Land & Fire Assessments Pty Ltd

Our Ref: LFA18020_TSA RFI response
Your Ref: TSA-RFI-000104

Response to TSA-RFI-000104 - Request for additional information DPE

AR-SKE-10-007

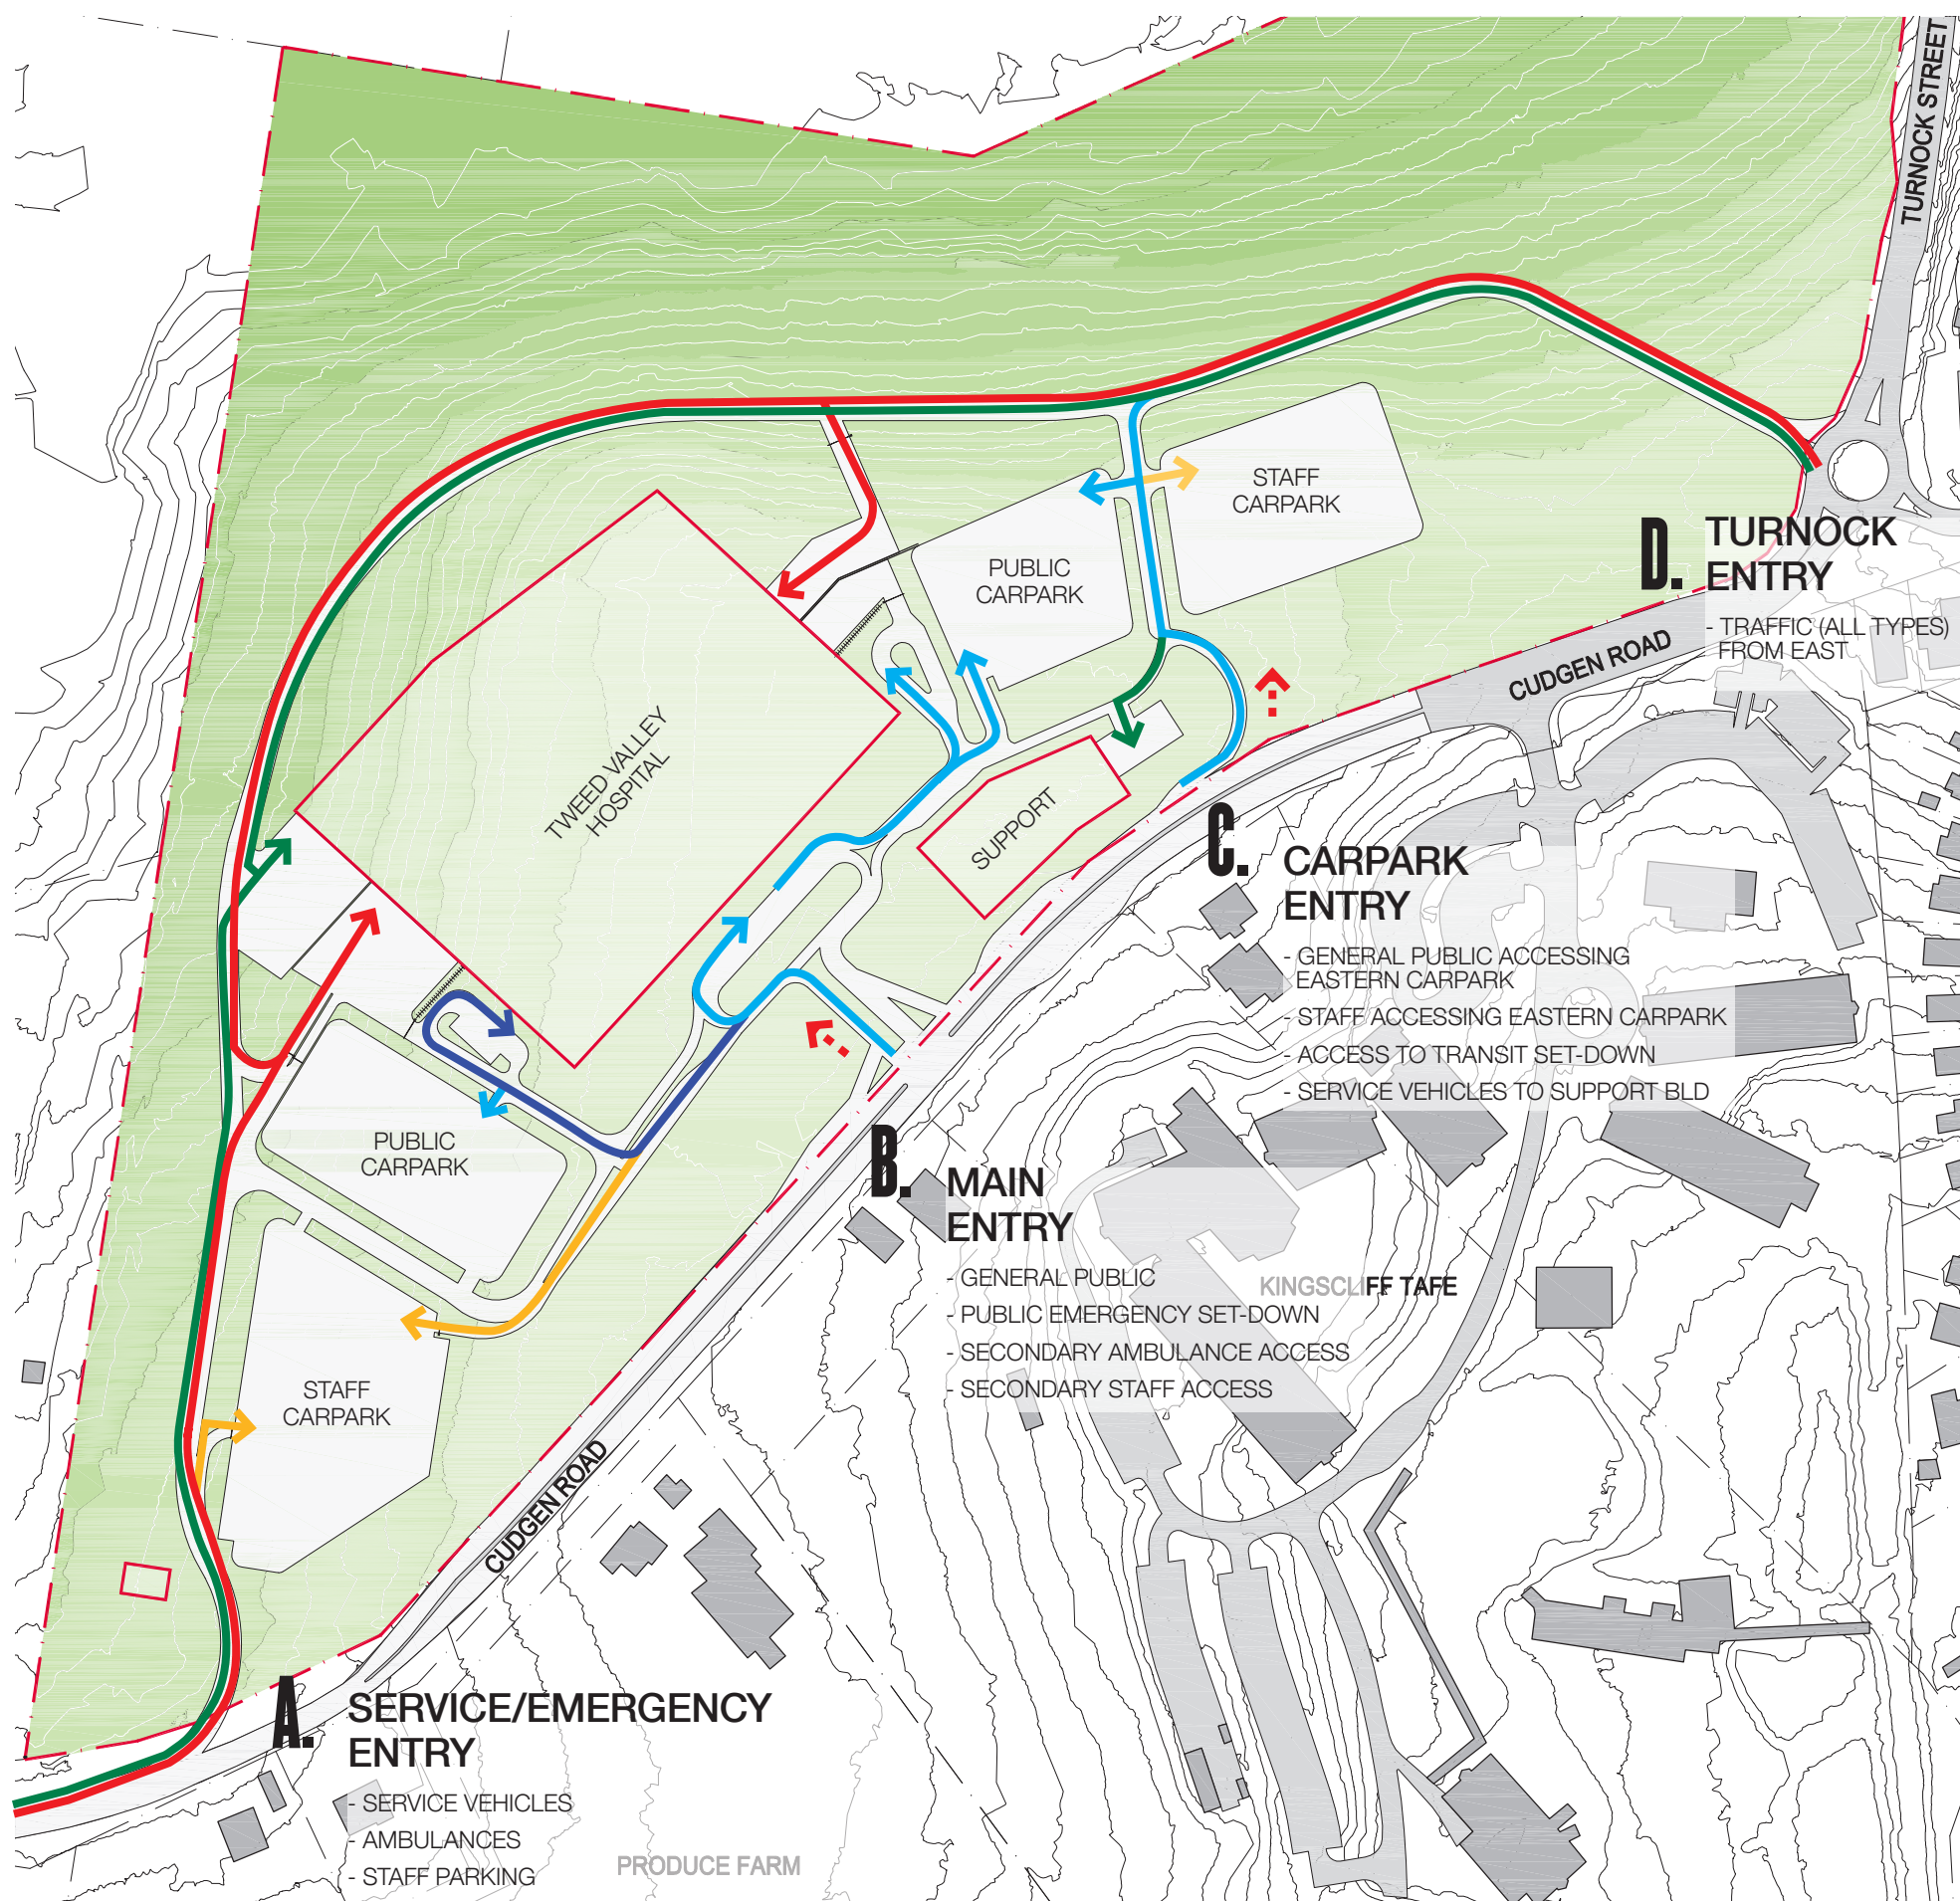
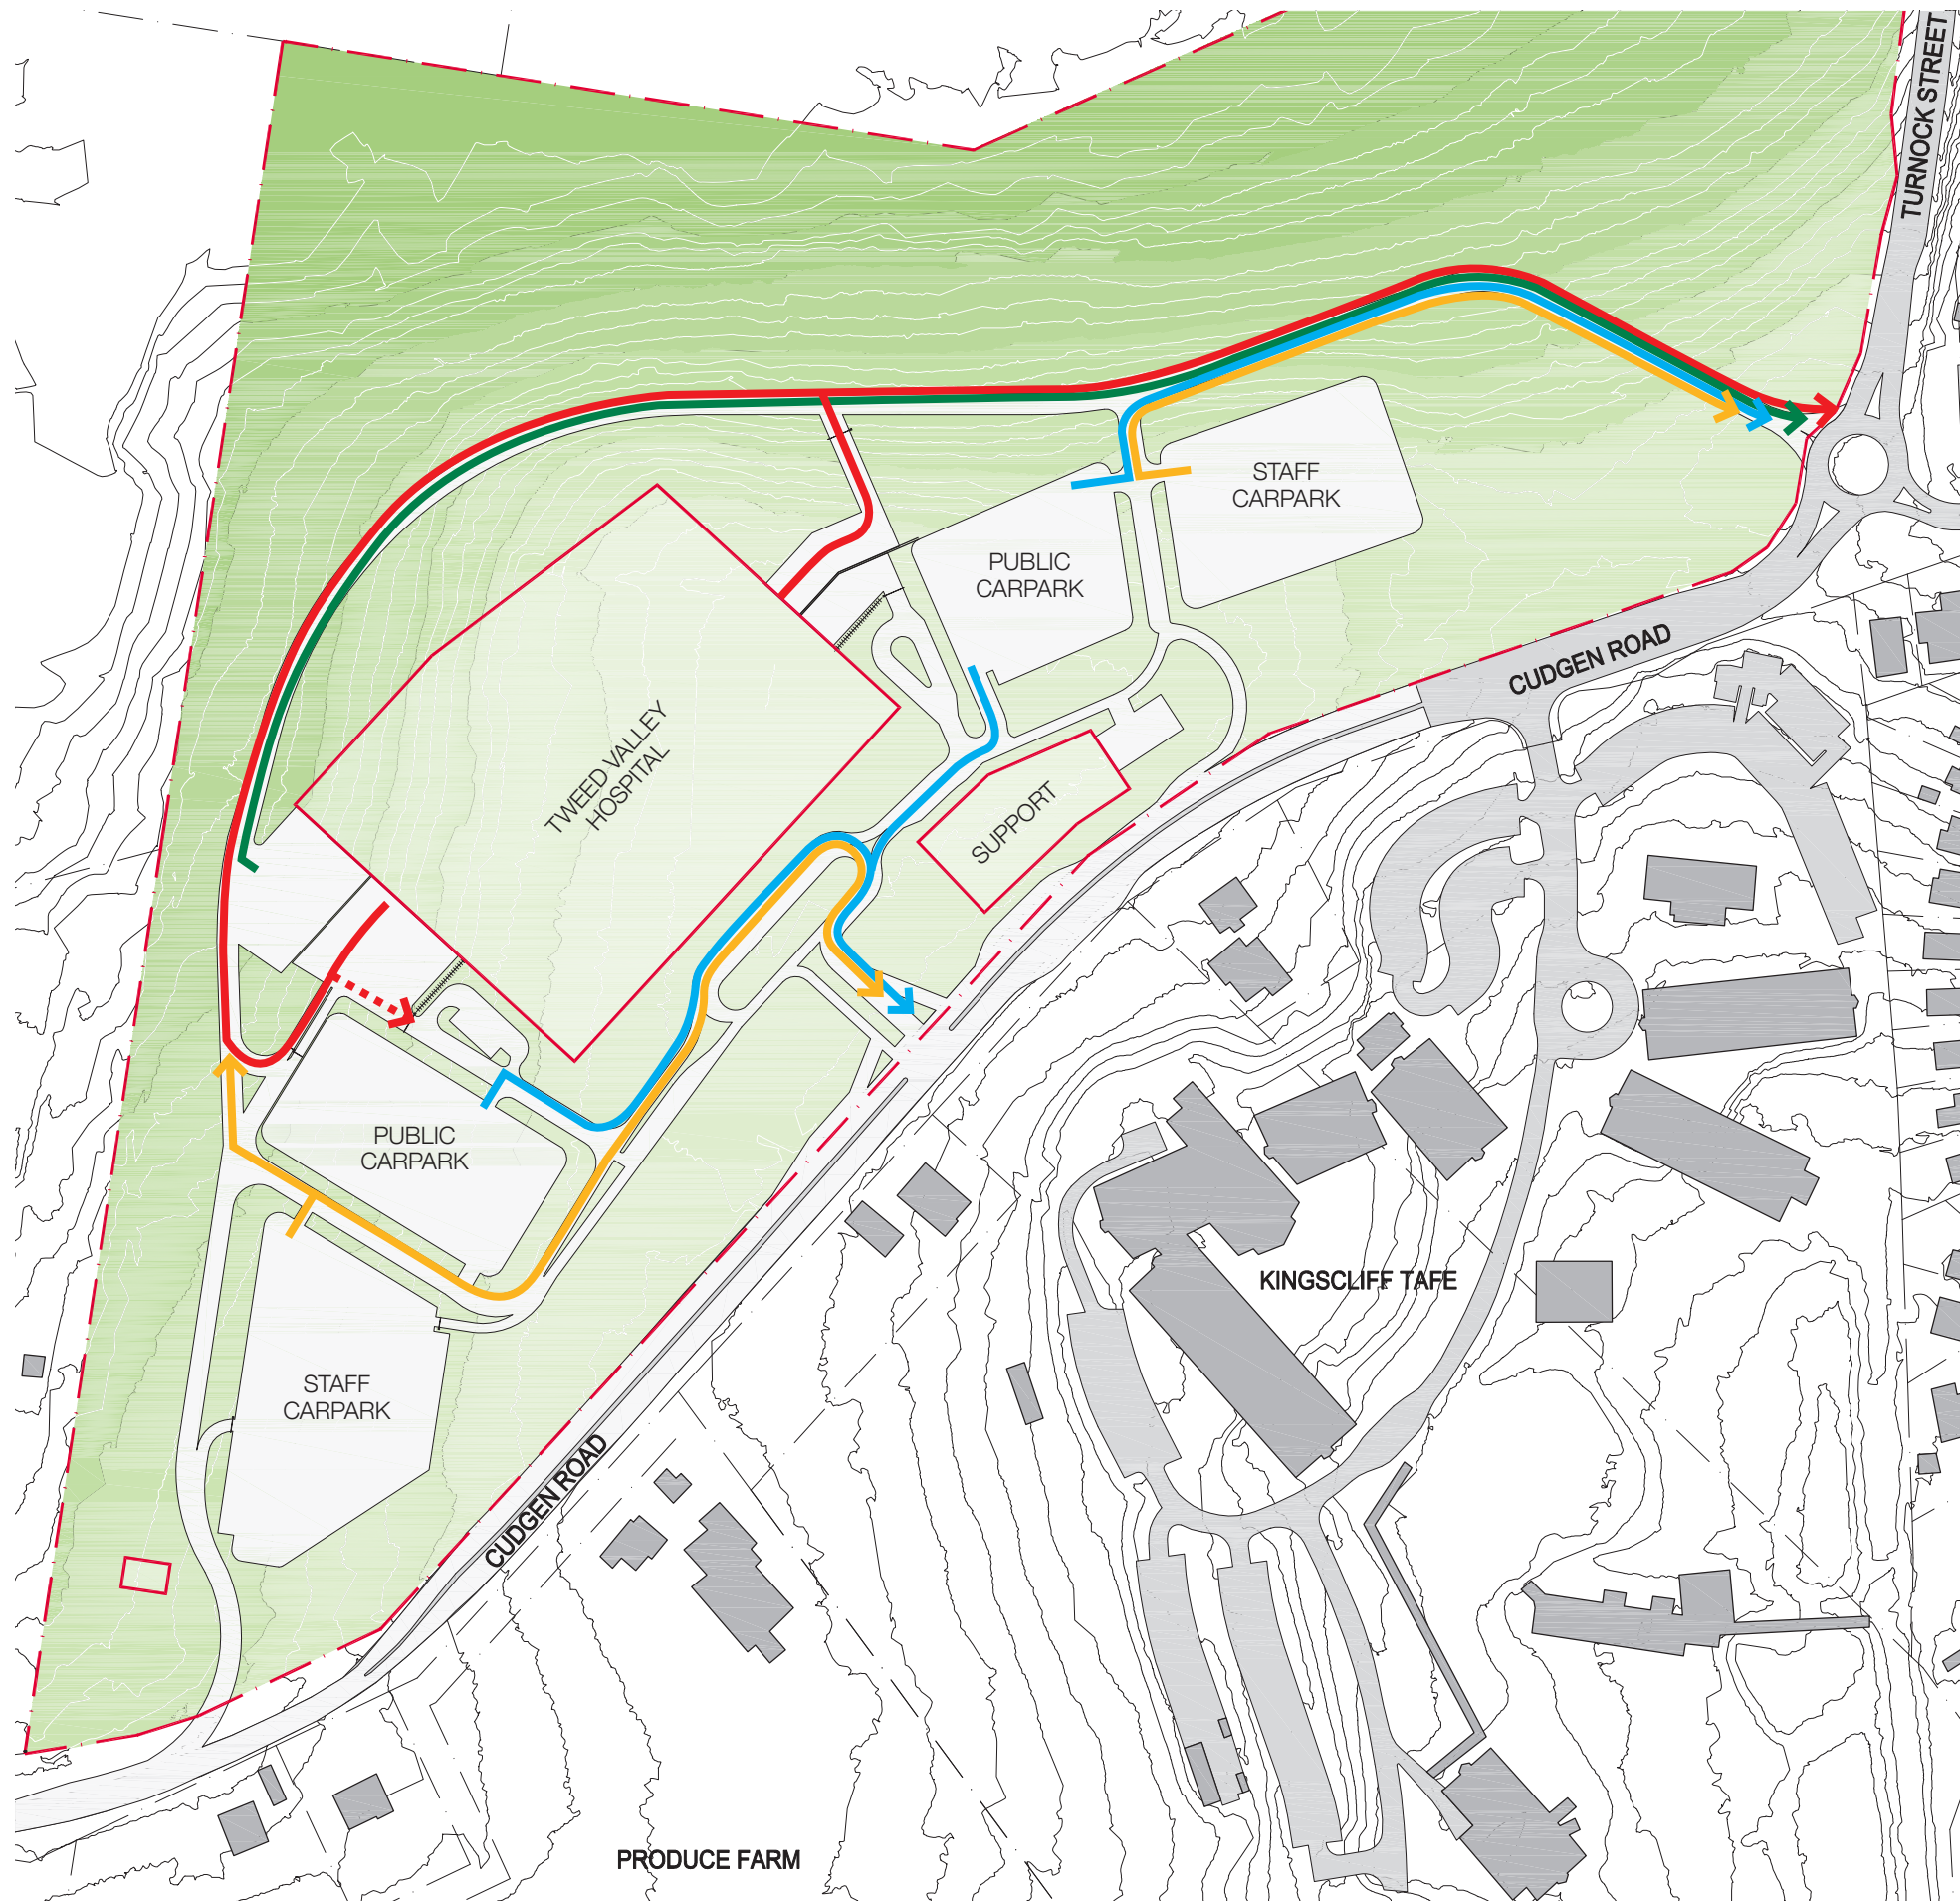
RFS have advised that the proposed development should be designed so that entry or exit point to the hospital building, including service delivery areas, are not exposed to more than 10kW of radiant heat exposure.

Thus a detailed assessment of whether 'entry or exit point to the hospital building, including service delivery areas, are not exposed to more than 10kW of radiant heat exposure' has not yet been undertaken. The masterplan does not provide distances or dimensions to be able to undertake this assessment. Nevertheless, neither entry or exit points as shown on the master plan currently, would be exposed to more than 10 kW/m² of radiant heat exposure as the south western and eastern

entry/exit points are respectively ~280m and ~165m away from the hazard (even if Lot 3 DP828298 were to be revegetated to Forested Wetlands).

The only unknown component in regard to the RFS comment is the proposed location of the service delivery areas. A service yard is identified on the masterplan, which would appear to be impacted if the land on Lot 3 DP828298 immediately to the west (currently cleared and used for grazing or the like) were to be revegetated to Forested Wetlands. We have not been provided with the distance between the service yard and the western boundary. However, using the Newcastle Consulting Bushfire Attack Calculator a distance of 49 m from the western boundary to the western side of the service yard would be required to achieve no more than 10kW (i.e. 9.95 kW/m²) of radiant heat exposure. The Calculator report, which also provides calculations for the entry/exit point is reproduced on Appendix B.
